Department of Environmental Health

July 16, 2009

RE: Harnett County Land Use Application #09-5-22425

SITE PLAN APPROVAL
DISTRICT RAVCR USE 18X 36
#BEDROOMS 0
7-8-09
ZONING ADMINISTRATOR

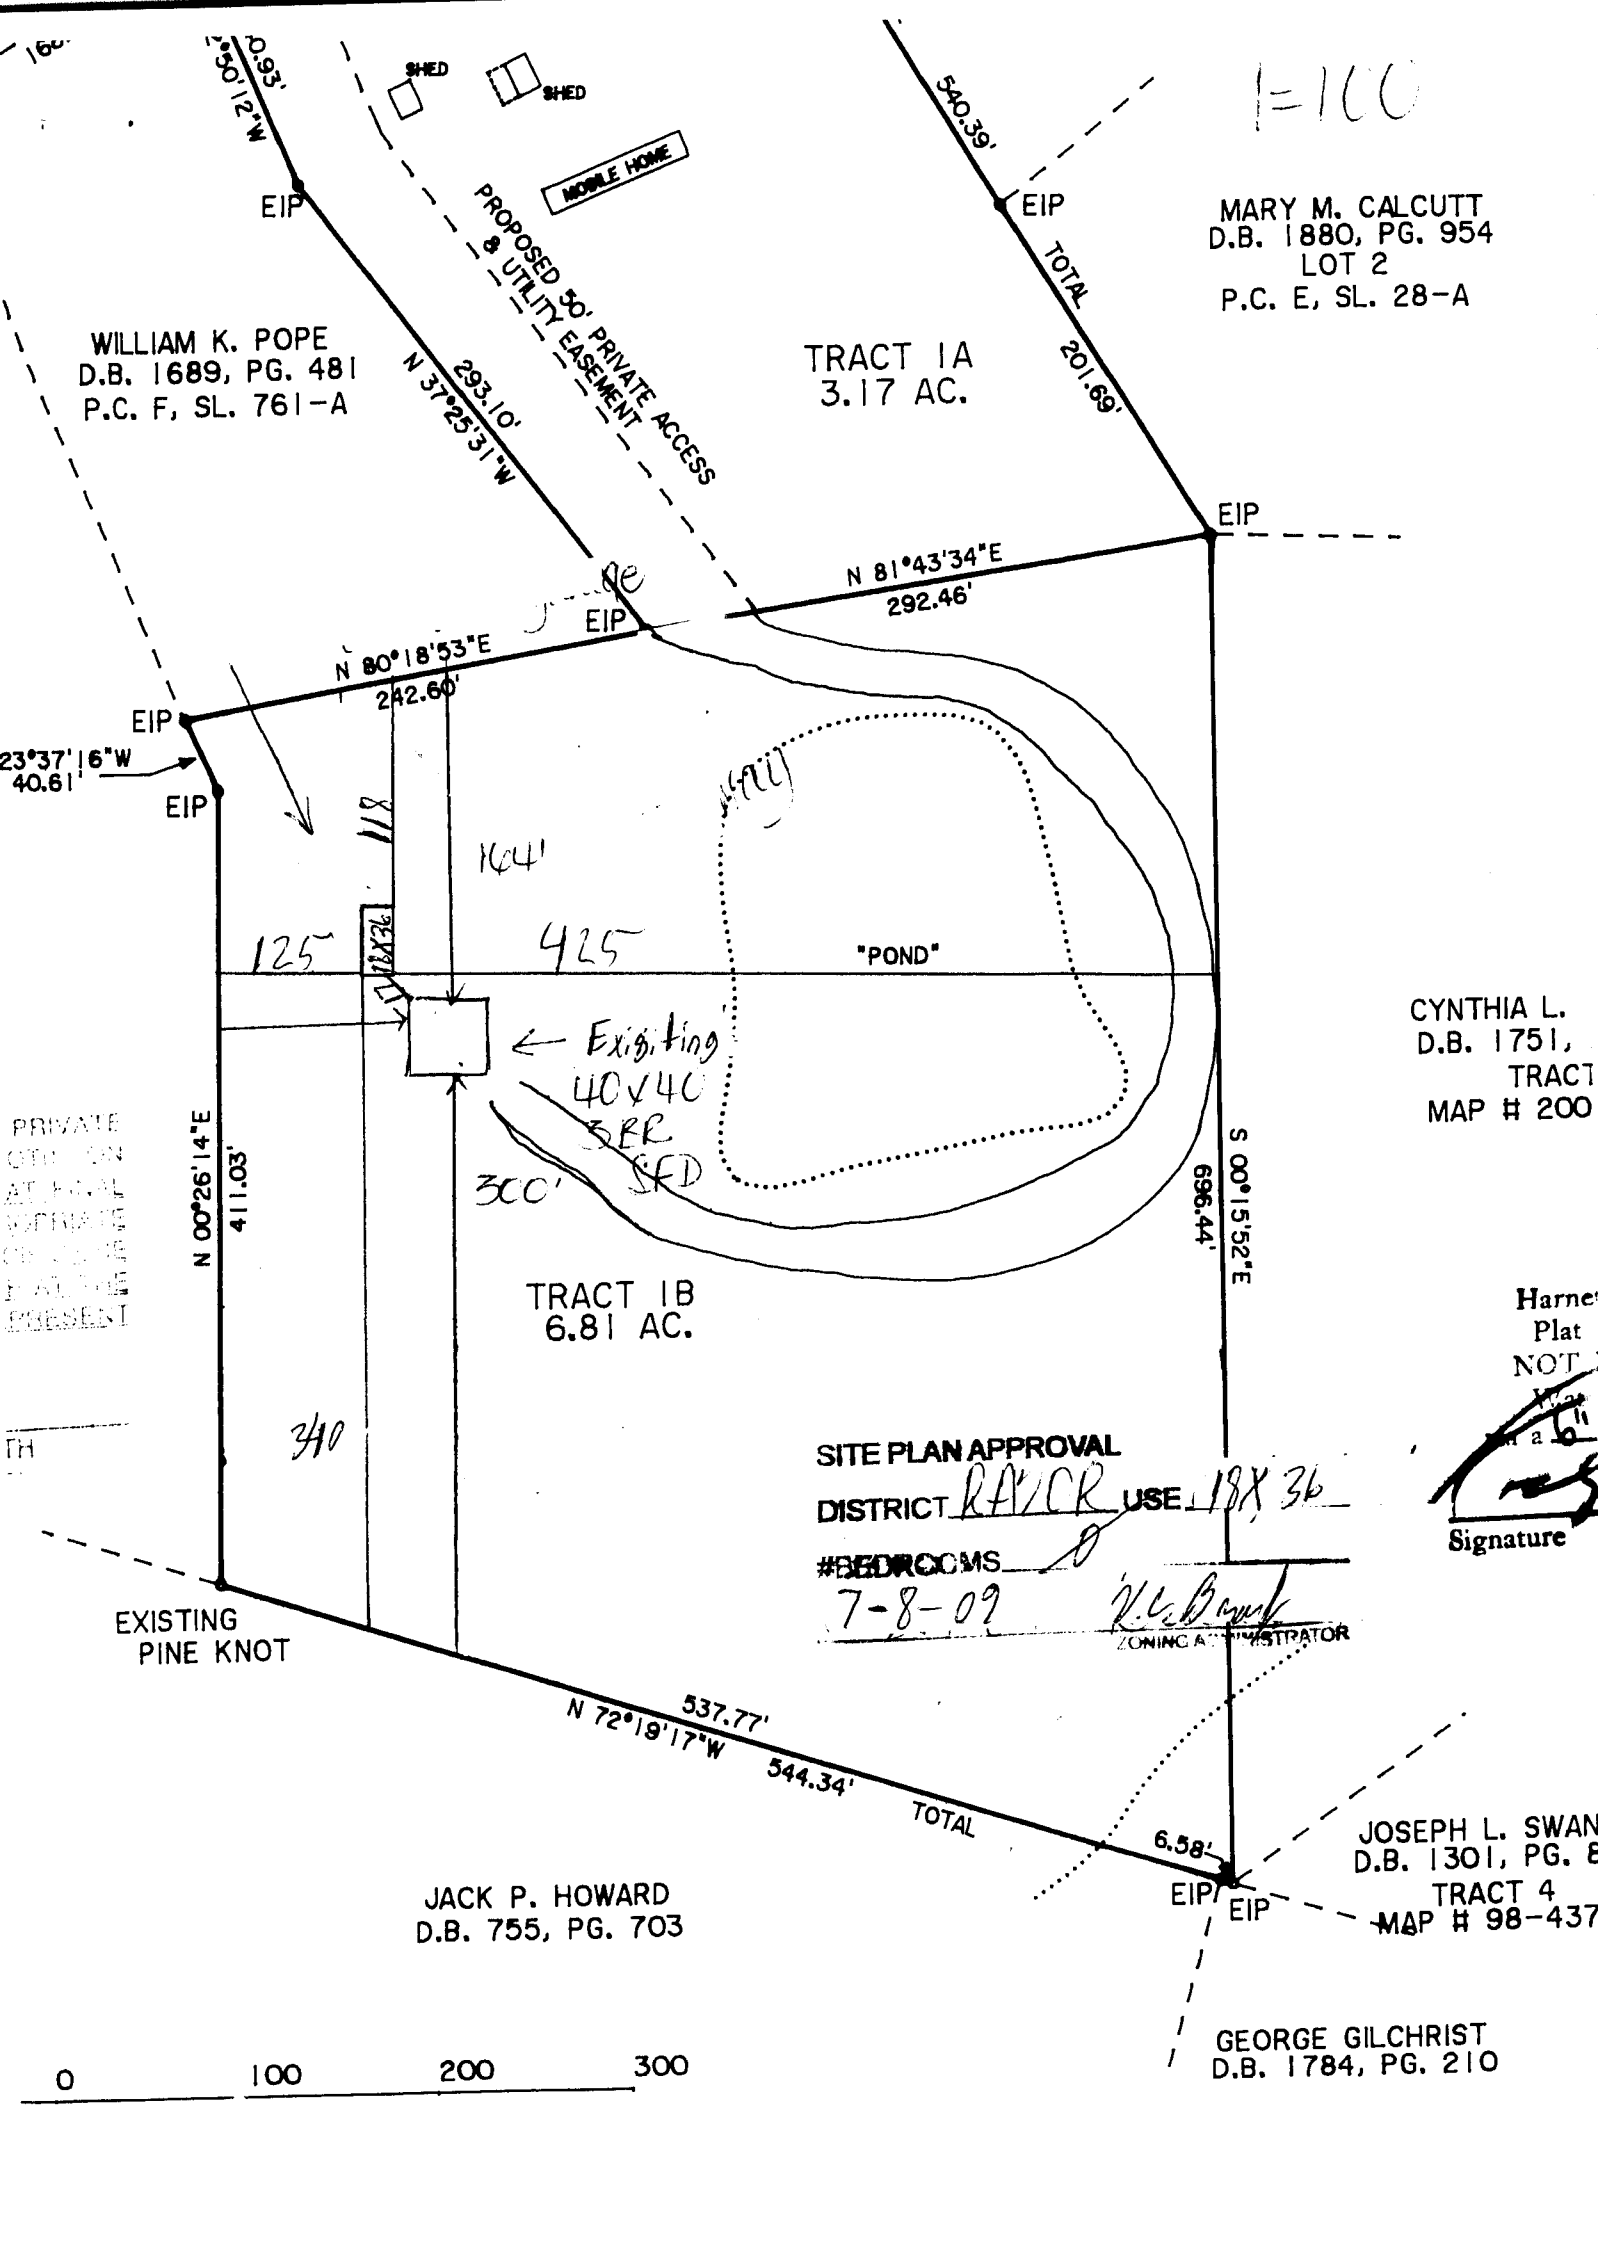
Based on the criteria set out in Title 15A, Subchapter 18A, of the North Carolina Administrative Code, Rules .1950, the evaluation indicated that the site is **UNSUITABLE** for the addition requested. Therefore, your request for an existing tank is **DENIED**. The site is denied based on the following:

X **15A NCAC 18A.1950{c} - Nitrification fields and repair areas shall not be located under paved areas or areas subject to vehicular traffic.**
